BEVERLY HUNT

WRITTEN REPRESENTATION

HIGHWAYS ENGLAND'S RESPONSE

M4 JUNCTIONS 3 TO 12 SMART MOTORWAY - TR010019

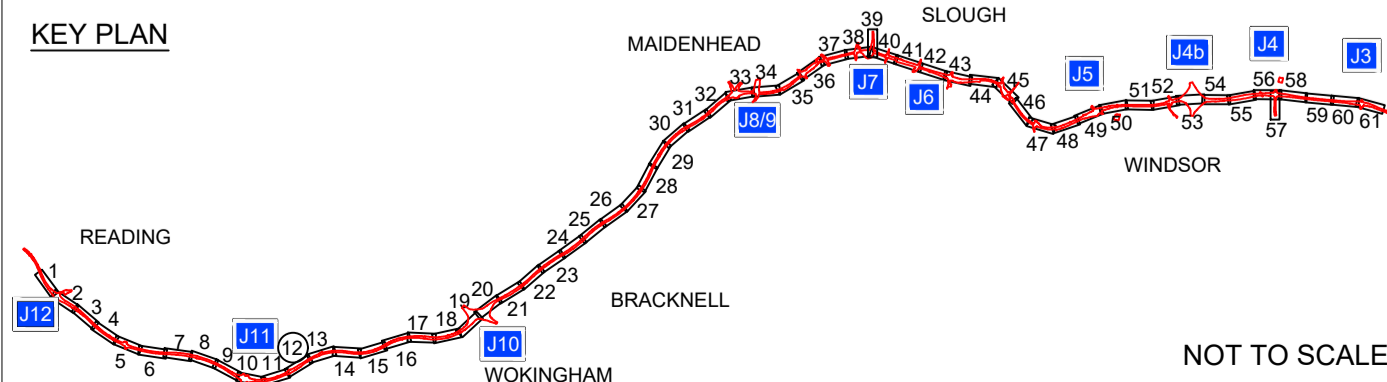
1.1 *Noise barrier at the end of the Myrke – we feel this should be extended further than currently planned. (to extend up to bridge) As it currently stands, this is simply insufficient.*

- 1.1.1 The proposed mitigation, to mitigate the effects of the M4 Junctions 3 to 12 Smart Motorway scheme (the “Scheme”), comprises low noise surfacing across all lanes, along the complete extent of the Scheme, and a number of new noise barriers. The locations and extents of these new noise barriers are provided in Drawing 12.2 (Application Document Reference 6-2, APP-257, APP-258, APP-259, and APP-260). There is a proposed new noise barrier to The Myrke (height 2.4 metres), as shown on Sheet 12 of Drawing 12.2 (APP-259).

- 1.1.5 Highways England confirms that the Myrke was subject to the assessment undertaken as part of the enhanced noise mitigation study. The confirmed barrier provision at the Myrke is detailed within Appendix E of the Enhanced Noise Mitigation Study (Ref 514451-MUH-00-ZZ-RP-EN-400158). Sheet 12 covers the Myrke area and maintains the previous commitment to provide a new 2.5m barrier on the westbound carriageway to the west of Datchet Road. The study has shown that this provision is more than adequate to mitigate the impact of the Scheme and (as is the case in most areas along the Scheme) the noise environment will actually be slightly improved (compared to the present day situation) once the Scheme is operational.
